City of Albuquerque

Re: Chapman Journal Center LOT 4, ~~7421 Hancock~~, Certificate of Occupancy
Engineer's Stamp dated 12-06-02 (D17/D85)
Certification dated 3-18-04

**Re: Chapman Journal Ctr. Development Grading and Drainage Plan
Engineer's Stamp dated 10-3-02 (D17/D85)**

**RE: Chapman Journal Center, Phase 2, Unit 1
Grading and Drainage Plan (D-17/D85)
Engineer's Stamp Dated December 6, 2002**

LOTS 3 & 4, JOURNAL CENTER

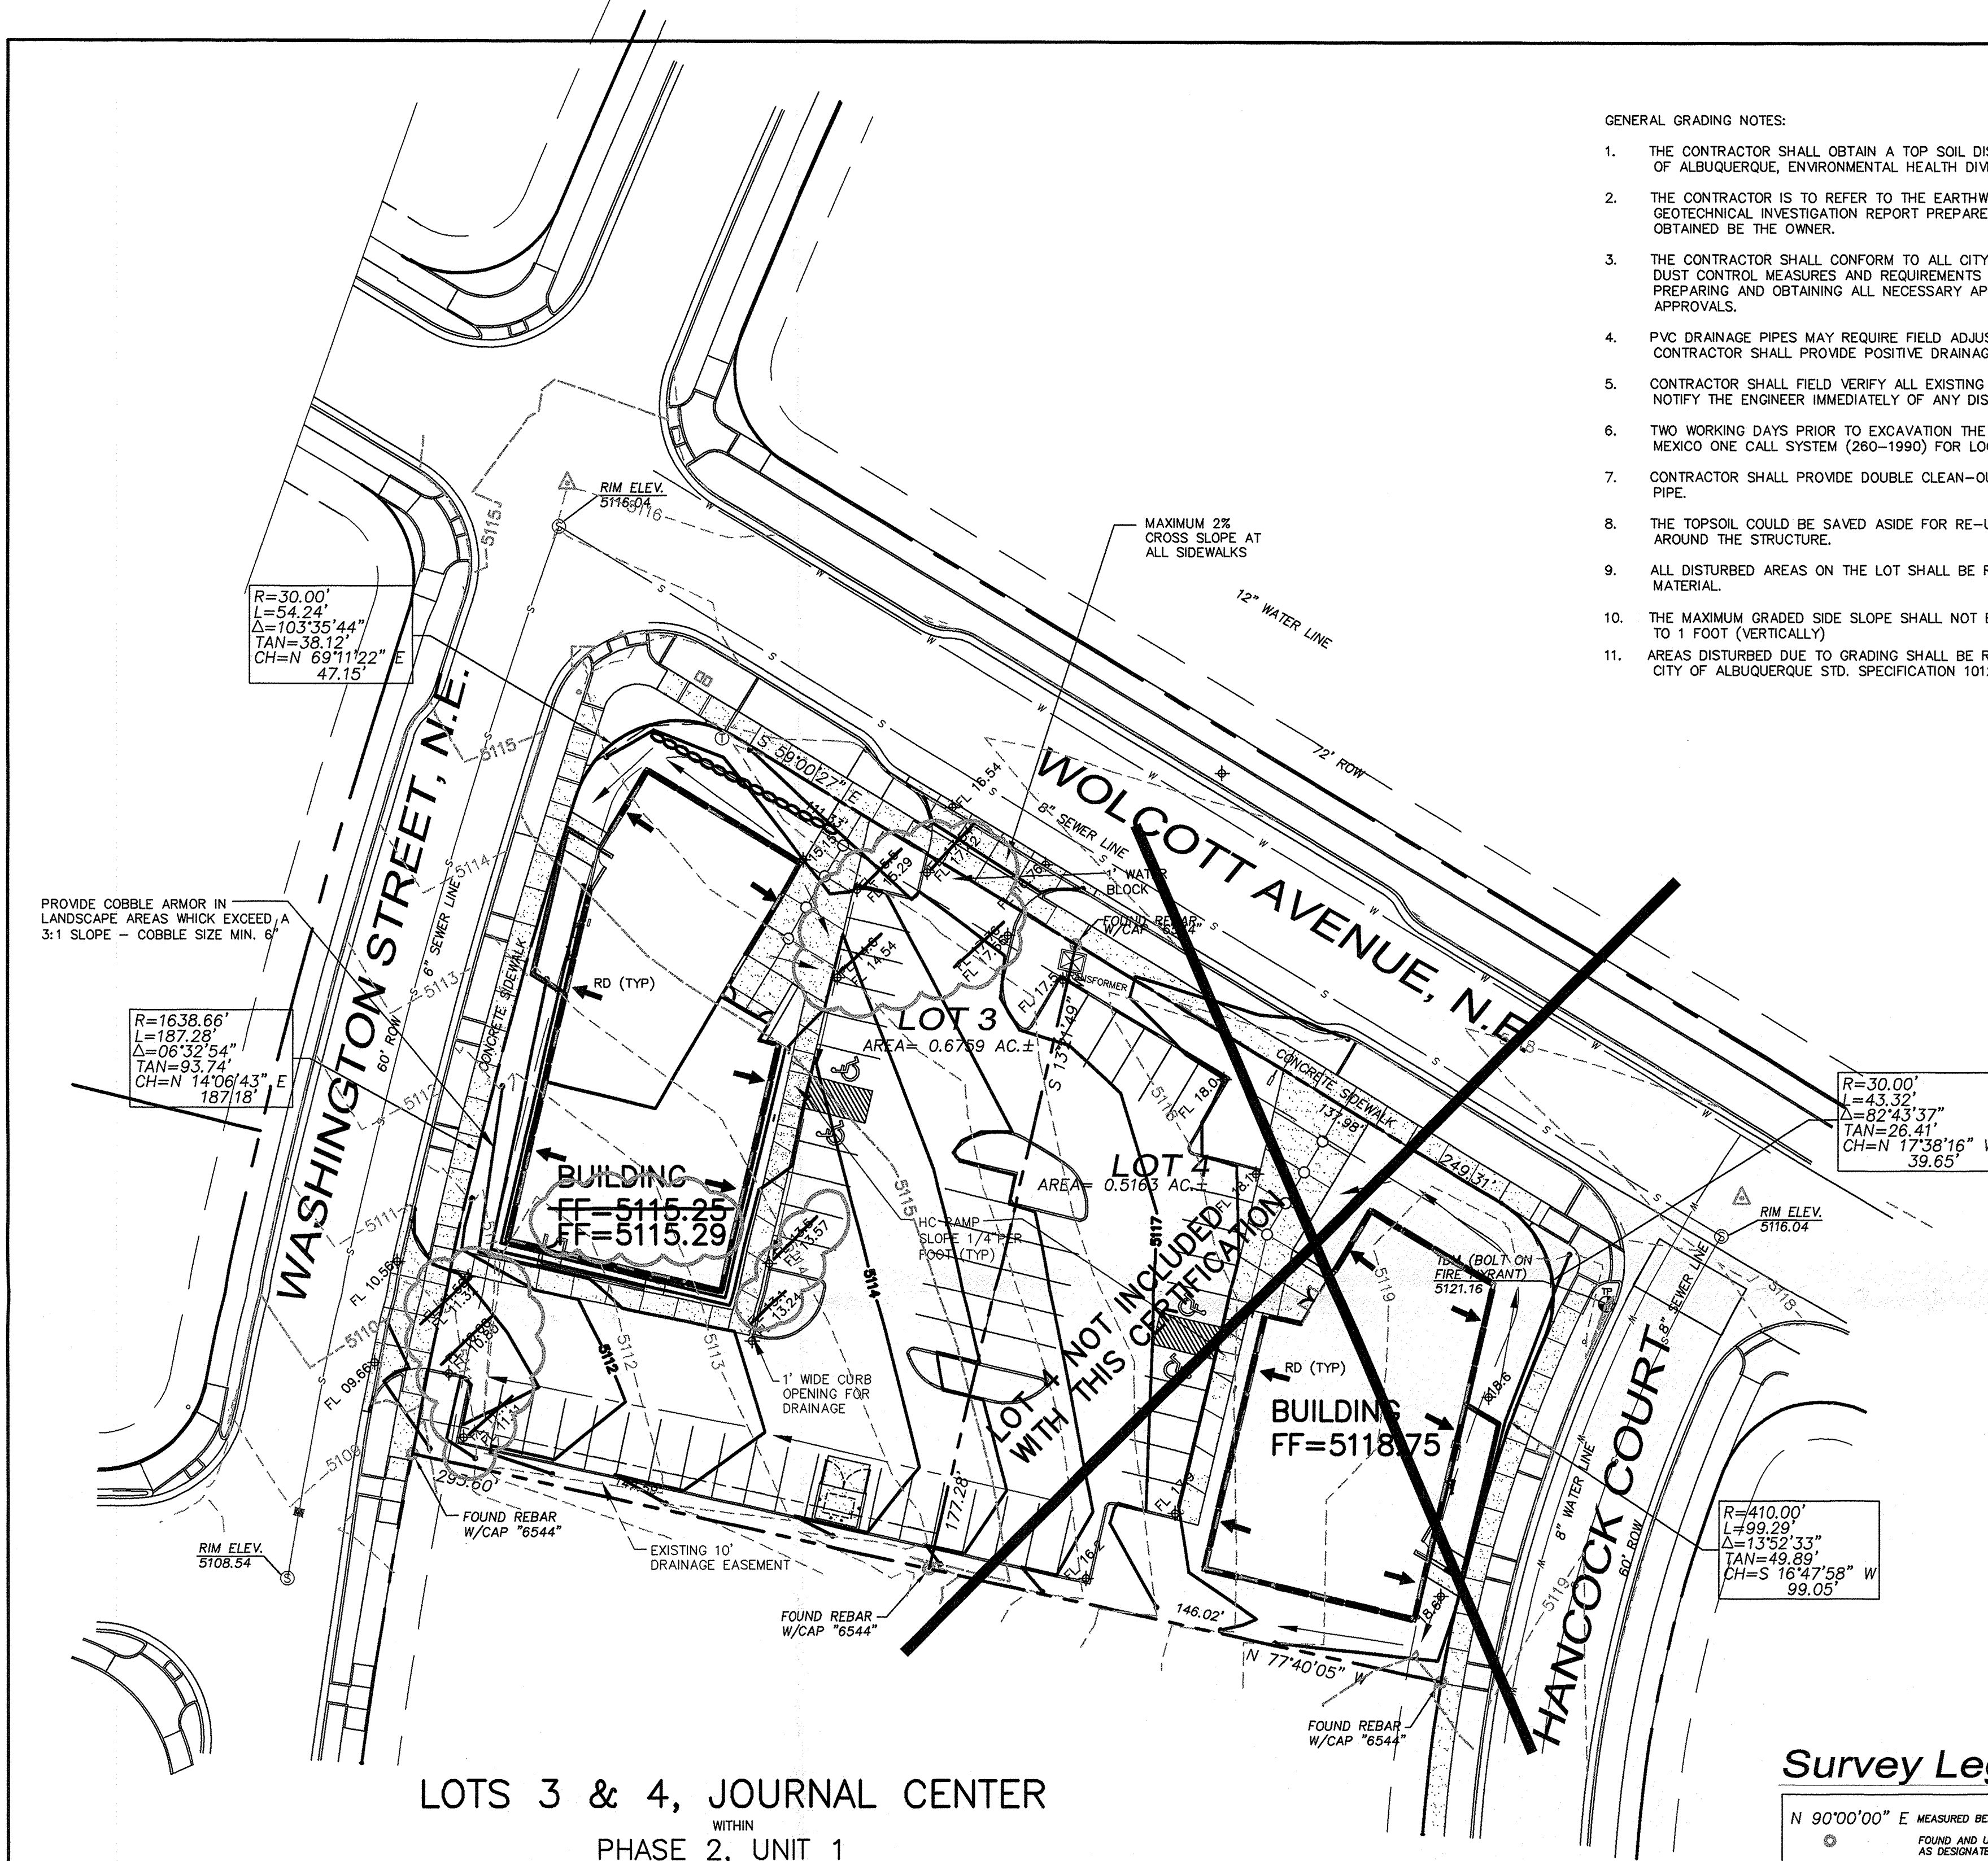
- A cross-lot drainage easement must be provided. If it is on the plat, please provide a copy of the plat.
- Please provide all spot elevations of the curb that are critical to the constructibility of this plan.
